## DECISION DELEGATED TO HEAD OF PLANNING

**Application No:** H08-0665-24      **Applicant:** Ms E Lenten  
**Proposal:** Proposed residential development  
**Location:** Adjacent To & Rear Of 68 Siltside Gosberton Risegate Spalding  
**Terminal Date:** 18th April 2025

## **CASE OFFICER ASSESSMENT**

PROPOSED INDICATIVE BLOCK PLAN

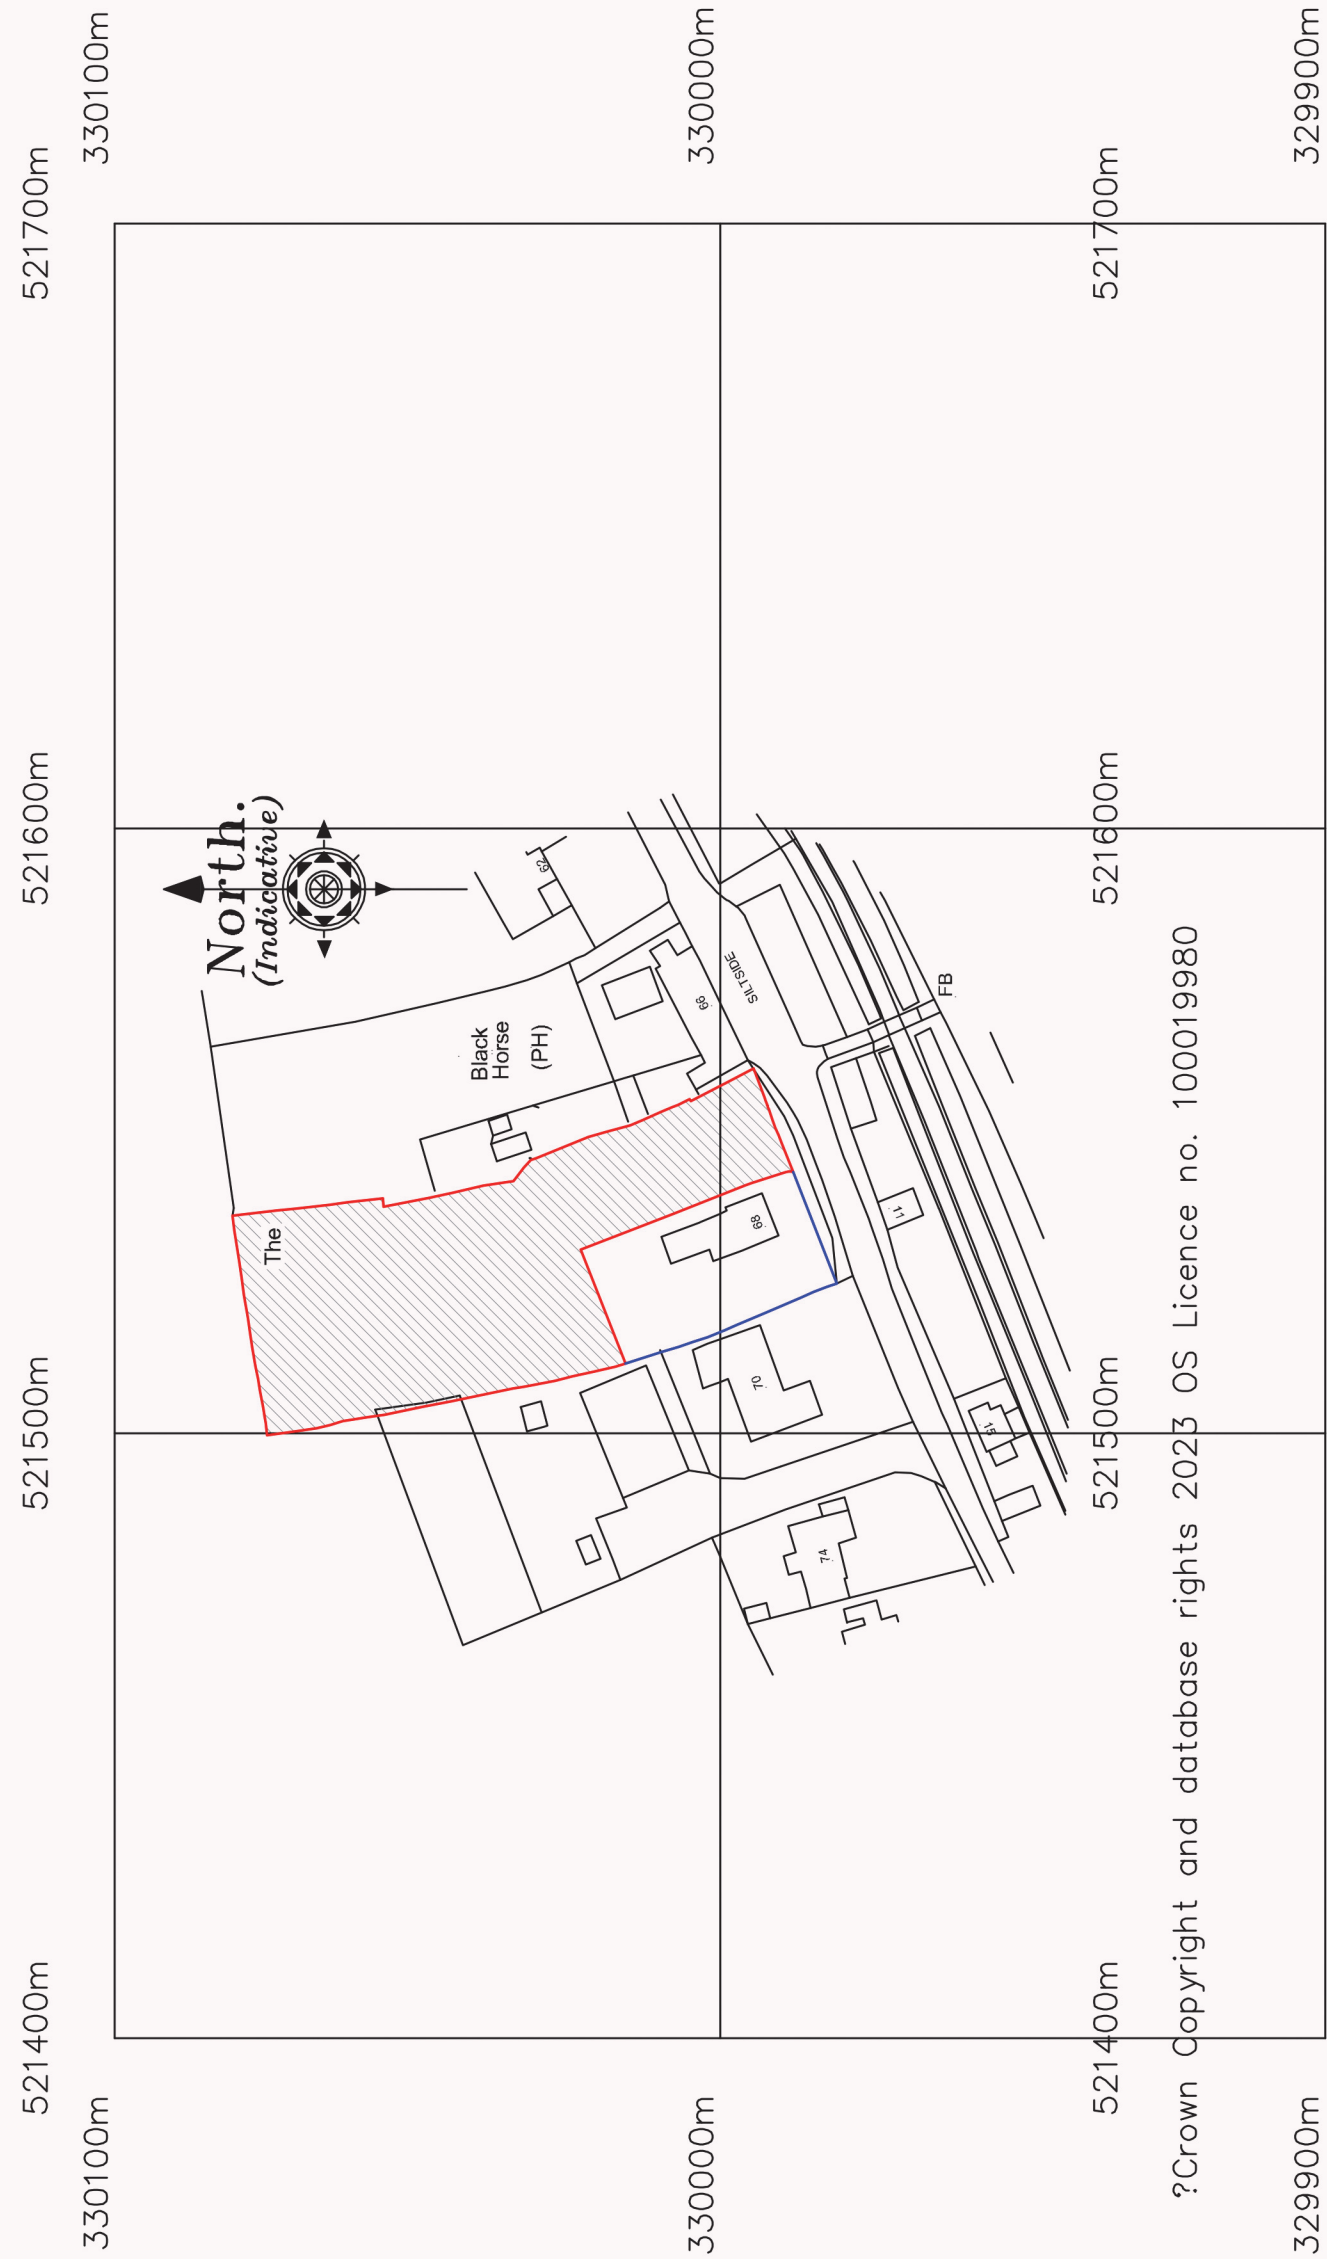
We would advise the applicant at this early stage and to support any further application, that the proposed access road is to be 4.1 metres wide as a minimum to allow the passage of two way vehicular movements. Additionally, further consideration is required to the access arrangements for plot 1, where they should utilise the new access road rather than a separate vehicle access I the interests of highway safety.

The proposal is in outline form. However, there is an indicative site layout showing three detached dwellings. The form of development would relate well with the urban grain in its setting. The plot onto the public highway would follow the frontage development. The footprint of the three properties would sit well within the site and considering the site area, the scheme would be of an appropriate density insofar as there would not be overdevelopment.

A residential property is situated directly to the south of the site, with a public house to the east. However, the indicative plan shows satisfactory separation distances could be achieved between the existing properties and the proposed new development generally. It is considered that the site could be developed without materially harming the amenity of nearby residents in terms of overlooking, lack of privacy, overbearing effect, overshadowing, noise, and disturbance, etc.
